Substitute plan for FP/82/19/PL

From: bob budd [REDACTED]
Sent: 15 May 2019 12:08
To: Amber Willard
Subject: 1, Summerley Lane Robert Budd

Ground and First Floor Plans

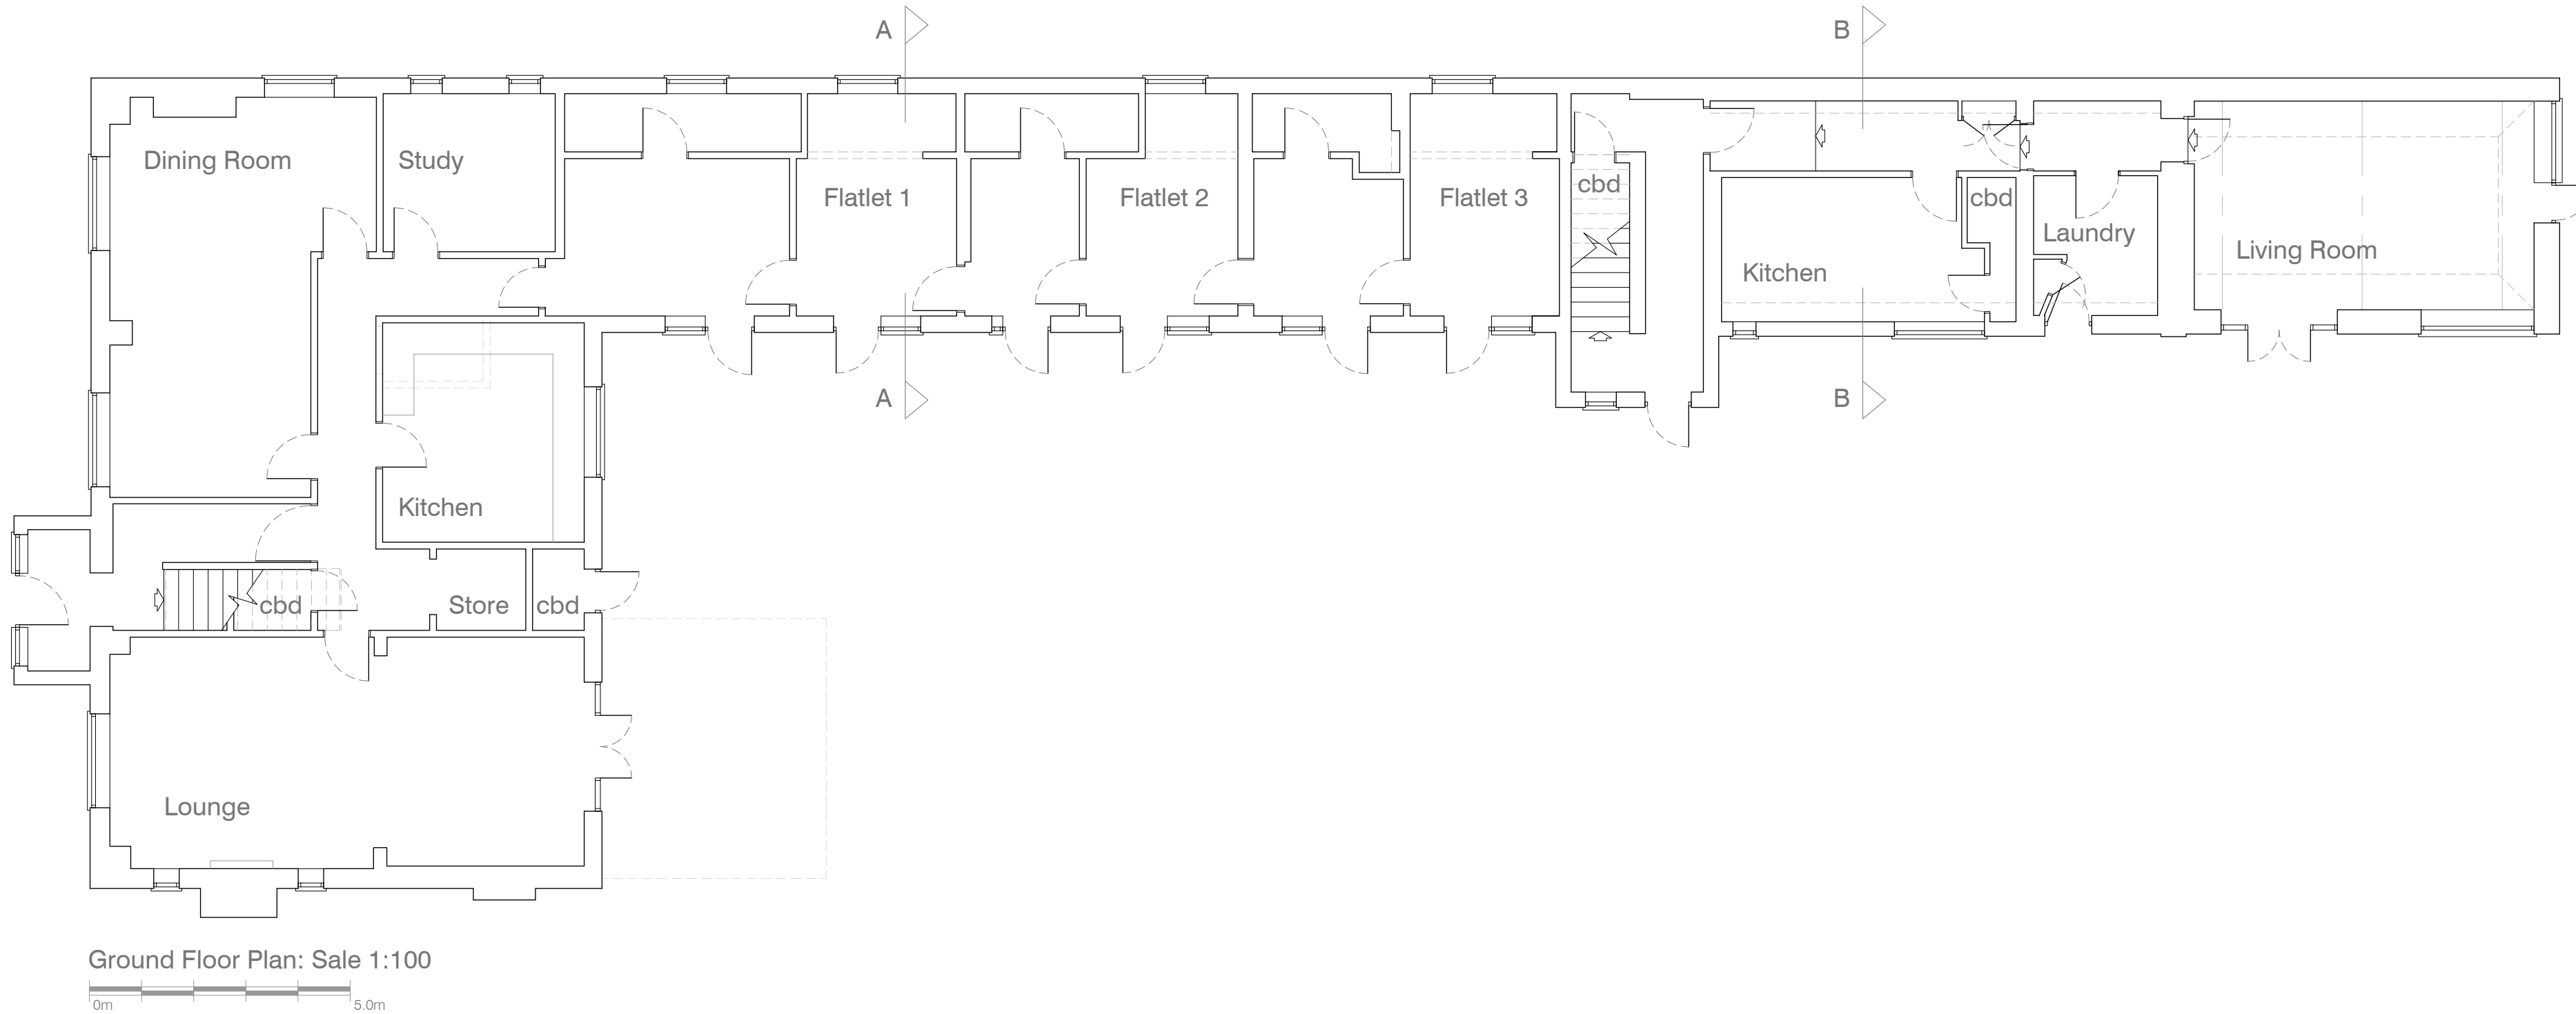
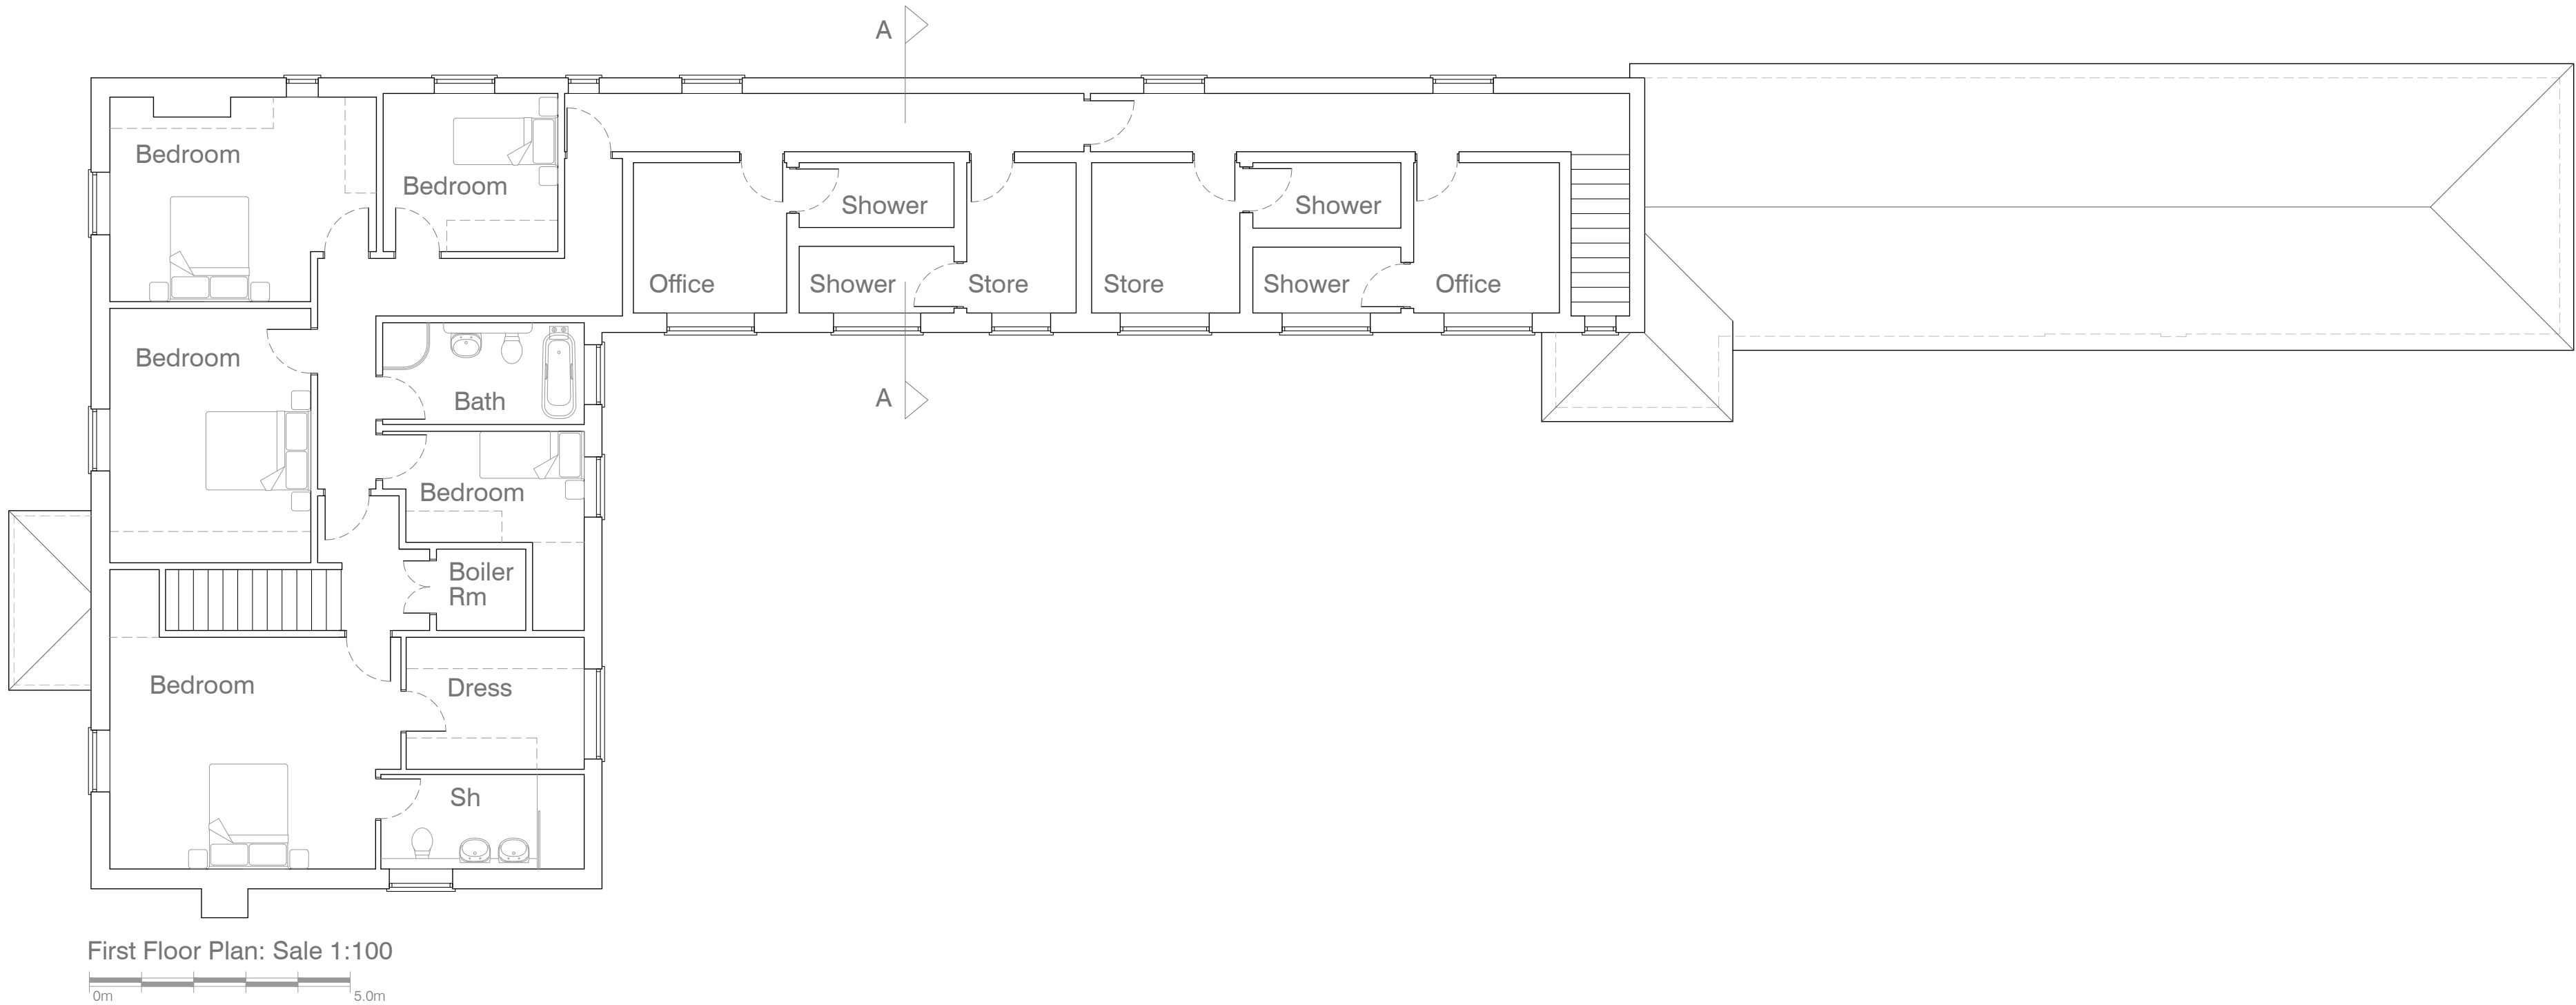
Hi Amber, I hope this reaches you, I am not the best with scanning.
The window size on the drawing is not to size.
The window size we hope to add is 600mm wide and 800mm deep.
Thankyou for your help.
Regards Robert Budd
